CITY OF ALBUQUERQUE

June 4, 2008

Re: Ed Romero Terrace Grading and Drainage Plan
Engineer's Stamp dated 4-30-08 (K19/D139)

ED ROMERO TERRACE
GRADING AND DRAINAGE PLAN

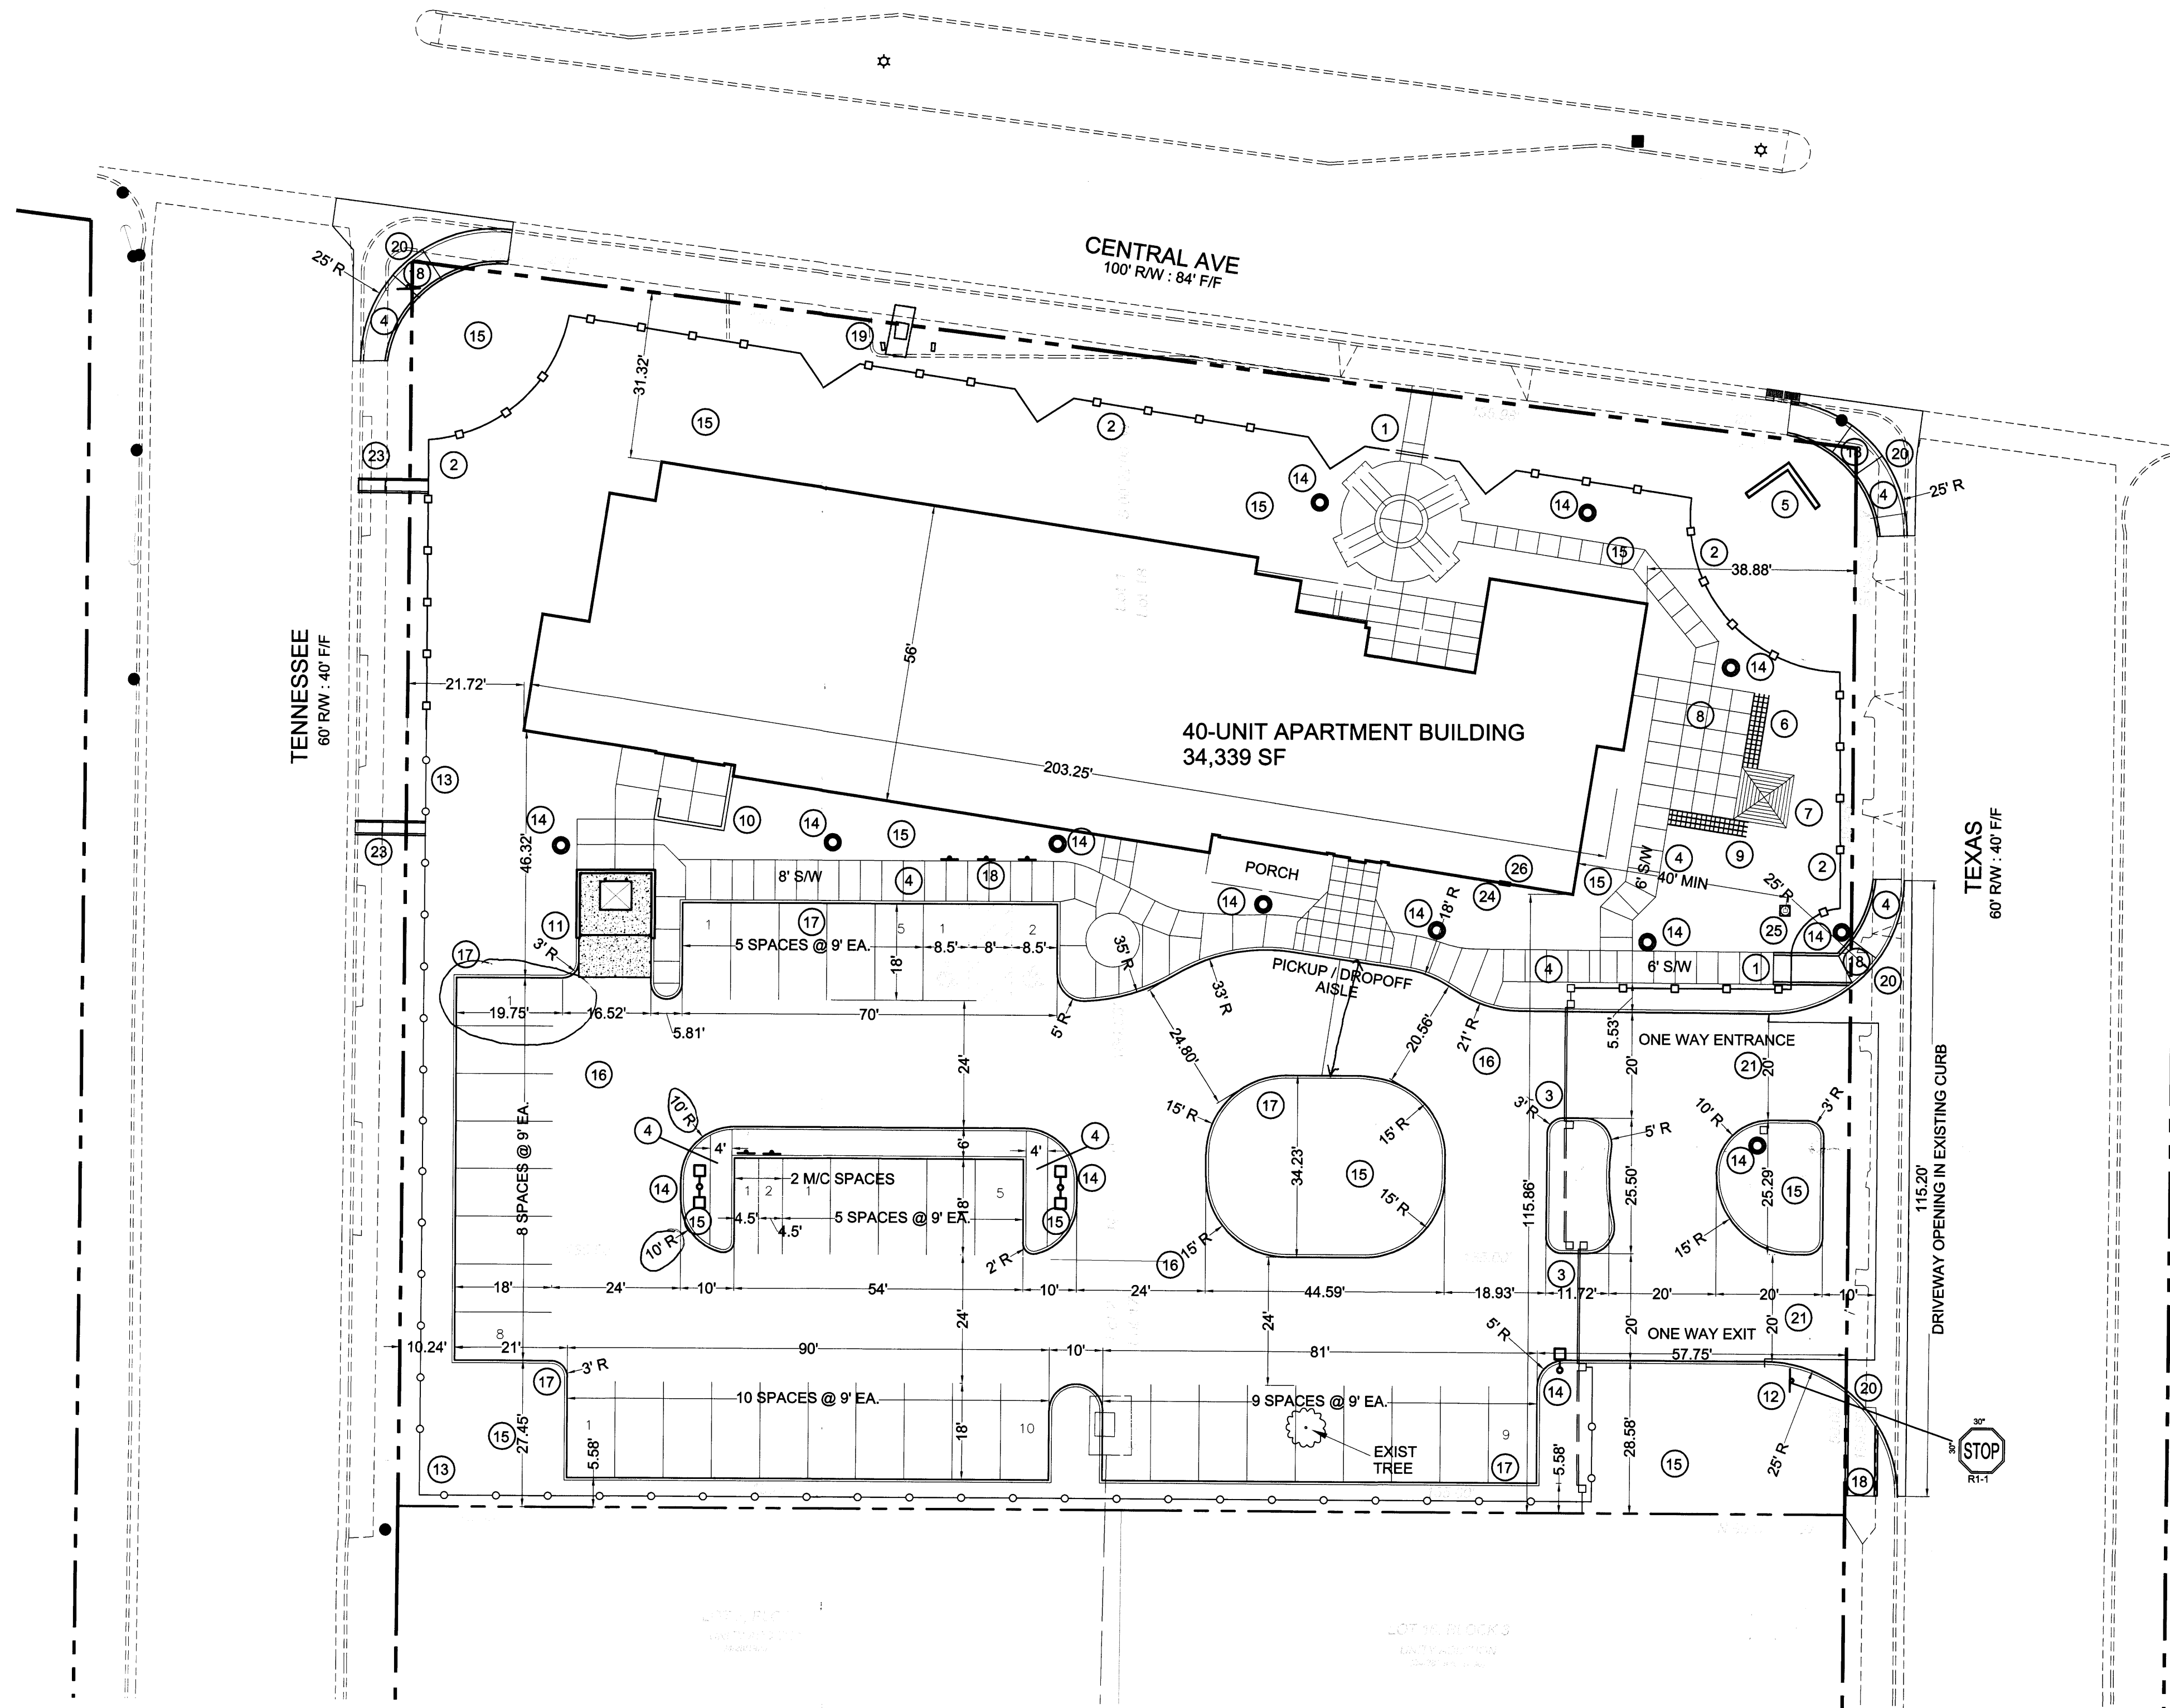
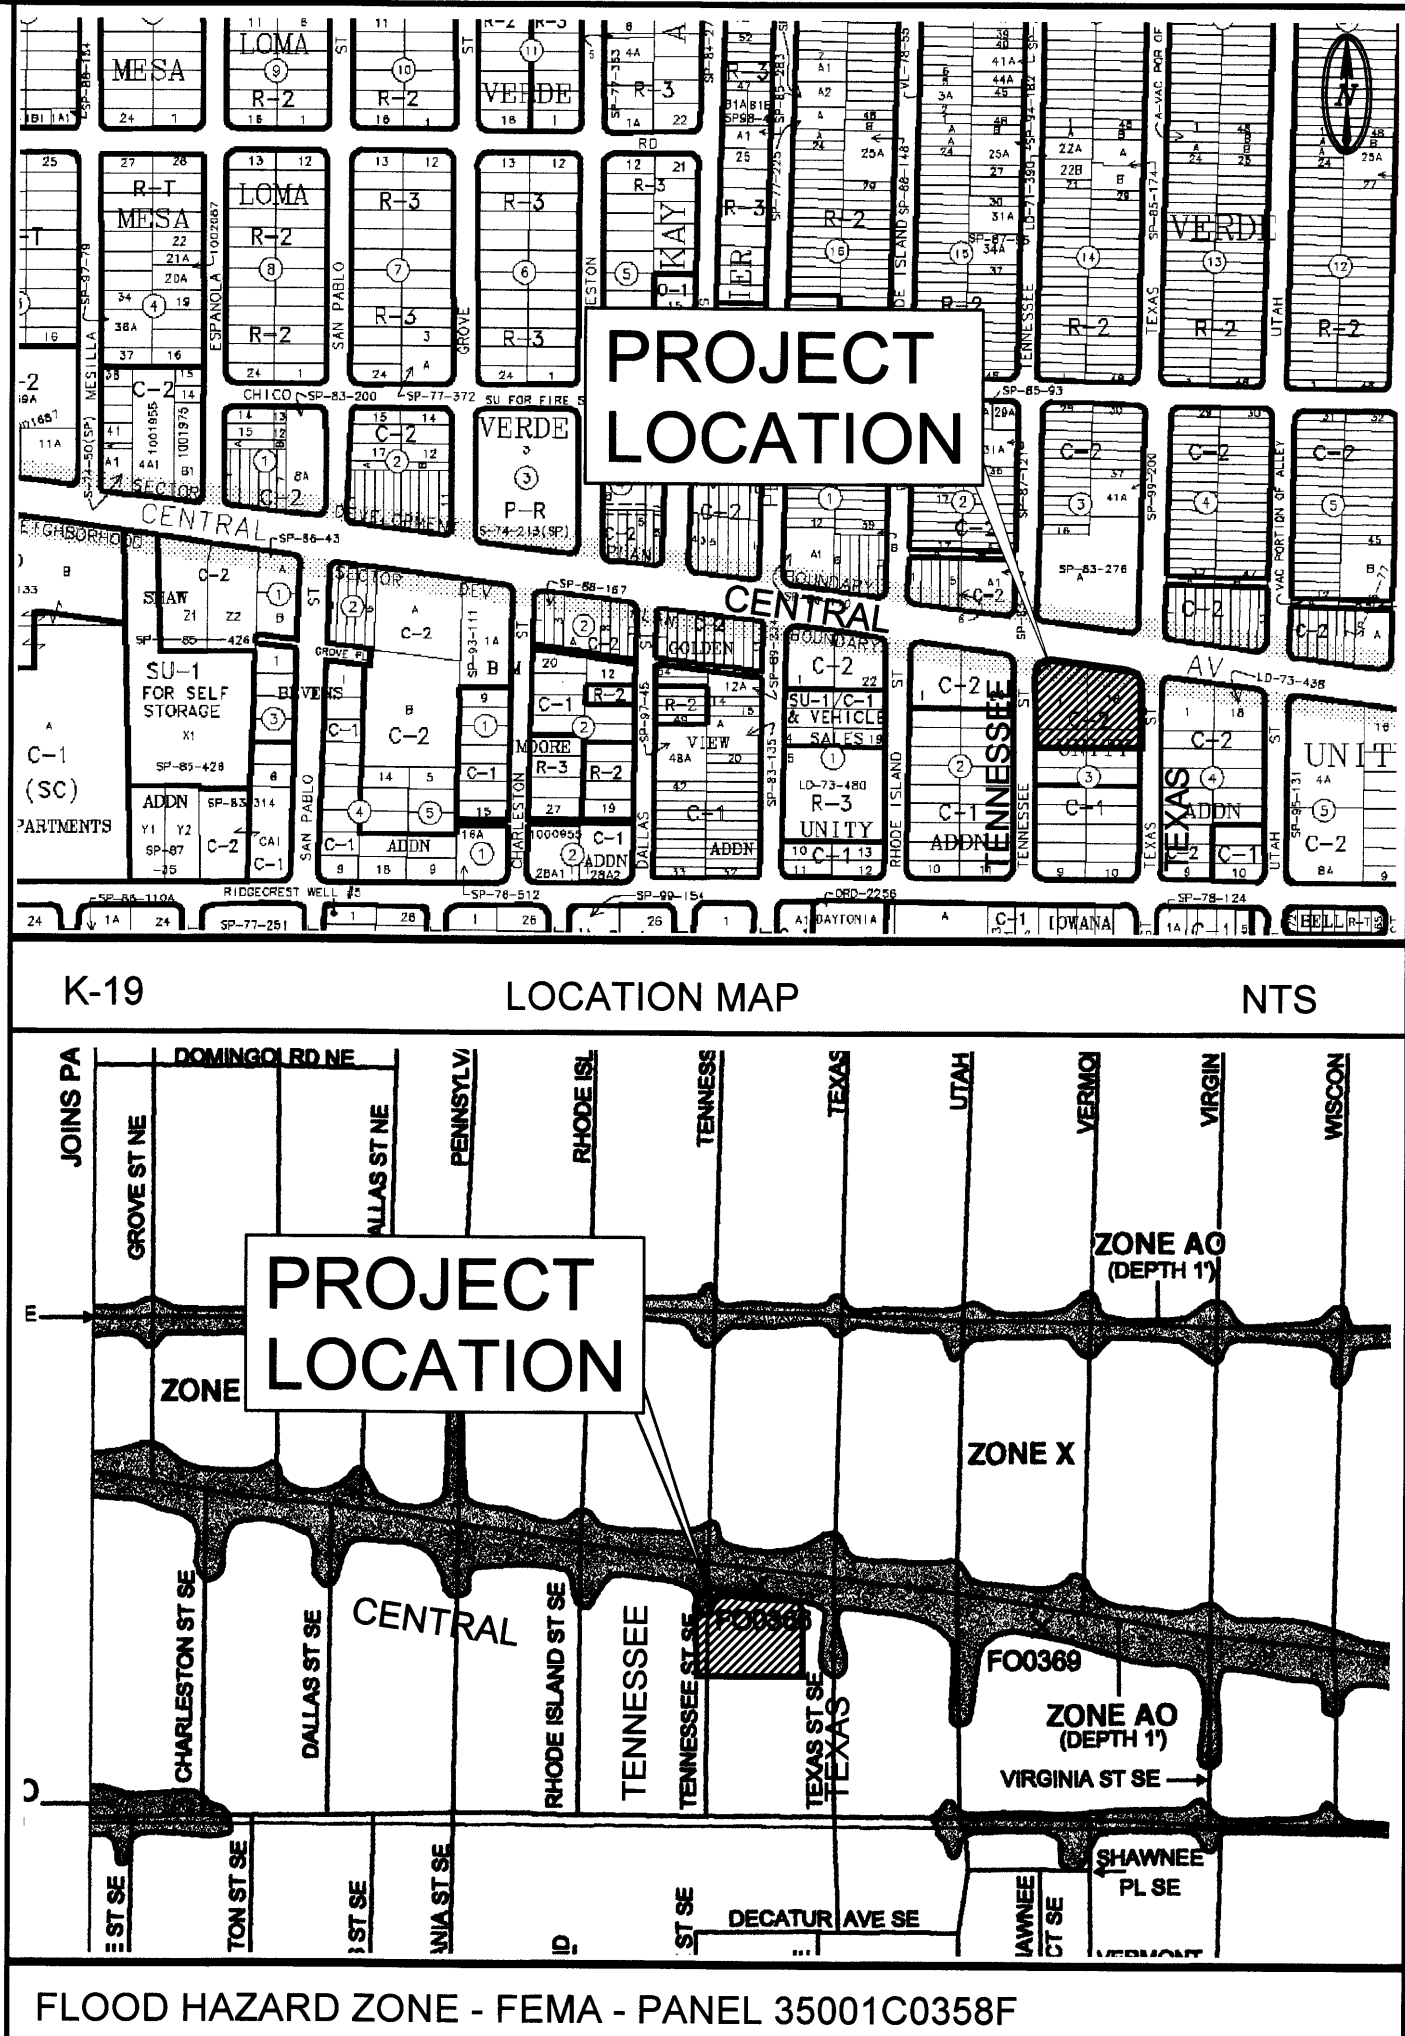
- Please show the sidewalk culvert on the plan and provide size, inverts and provide enough spot elevations or contours to show me how the runoff will get to the culvert. Add City Standard Drawing number and add the notes to contractor on this plan
- What size is the curb opening? Provide build note.
- Will there be curb openings at the middle island or are they flush with the asphalt. The contours would suggest as much.
- Provide a cross-section of the swale noted along the wall.
- Provide more spot elevations to describe what is happening at the entrance, the islands and landscape areas on the south side.
